**Subject:** FW: Fw: 2023/91032 - 12 Highroyd, Lepton, Huddersfield, HD8 0EB  
**Date:** 04 July 2023 11:41:04

Paul Farndale  
Kirklees LLFA

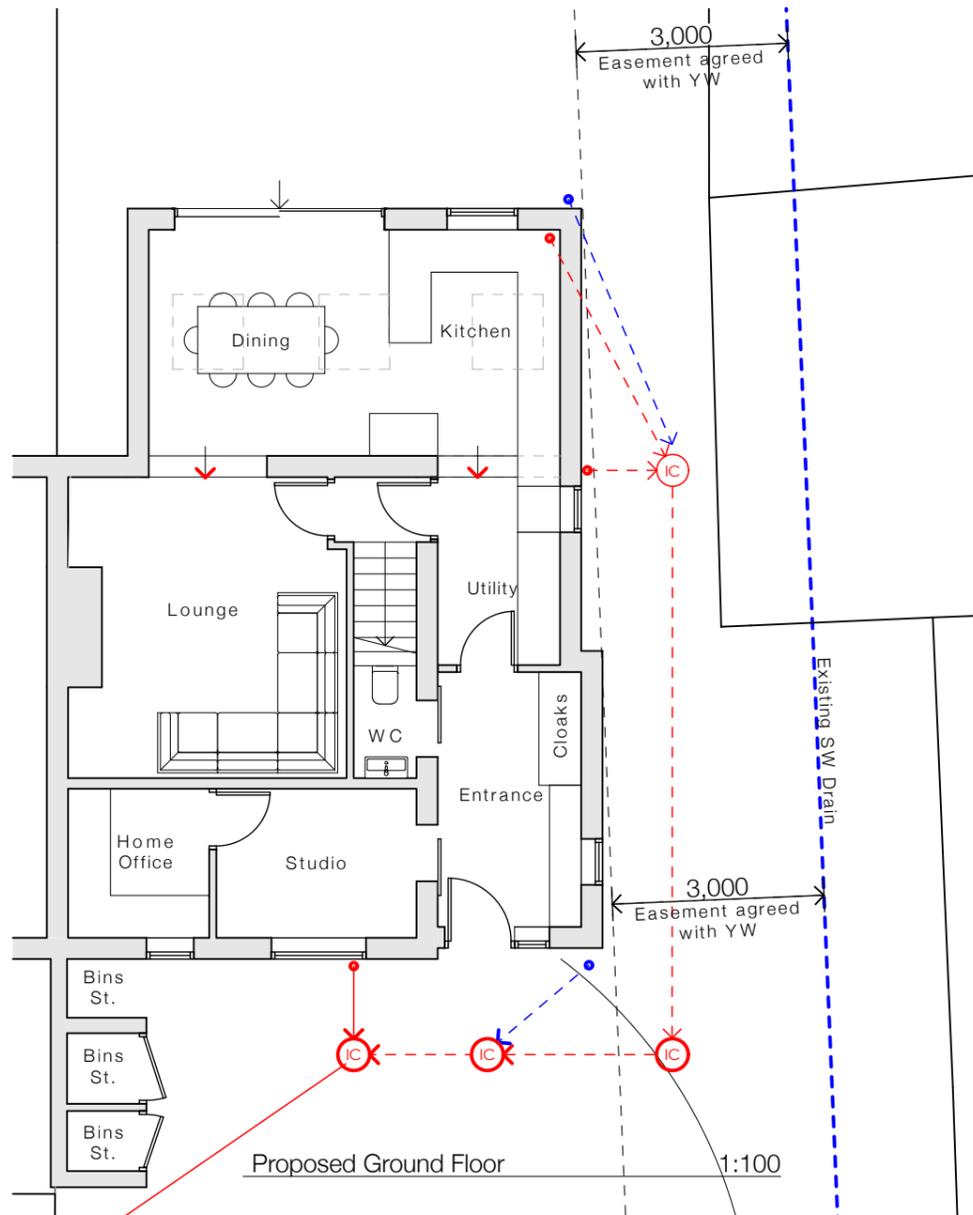
Further to our previous consultation responses, we have now met the applicant on site and carried out some survey work. We now believe that the culvert shown on our plans is only guess as to where a culvert may have run between open sections of watercourse on historical plans. It seems almost certain as the area was development that any flows were intercepted into a new surface water public sewer which is also shown through the property. This has been surveyed and is clear of the extension proposed.

We therefore can remove our objection to the application. Yorkshire Water may wish to comment separately.
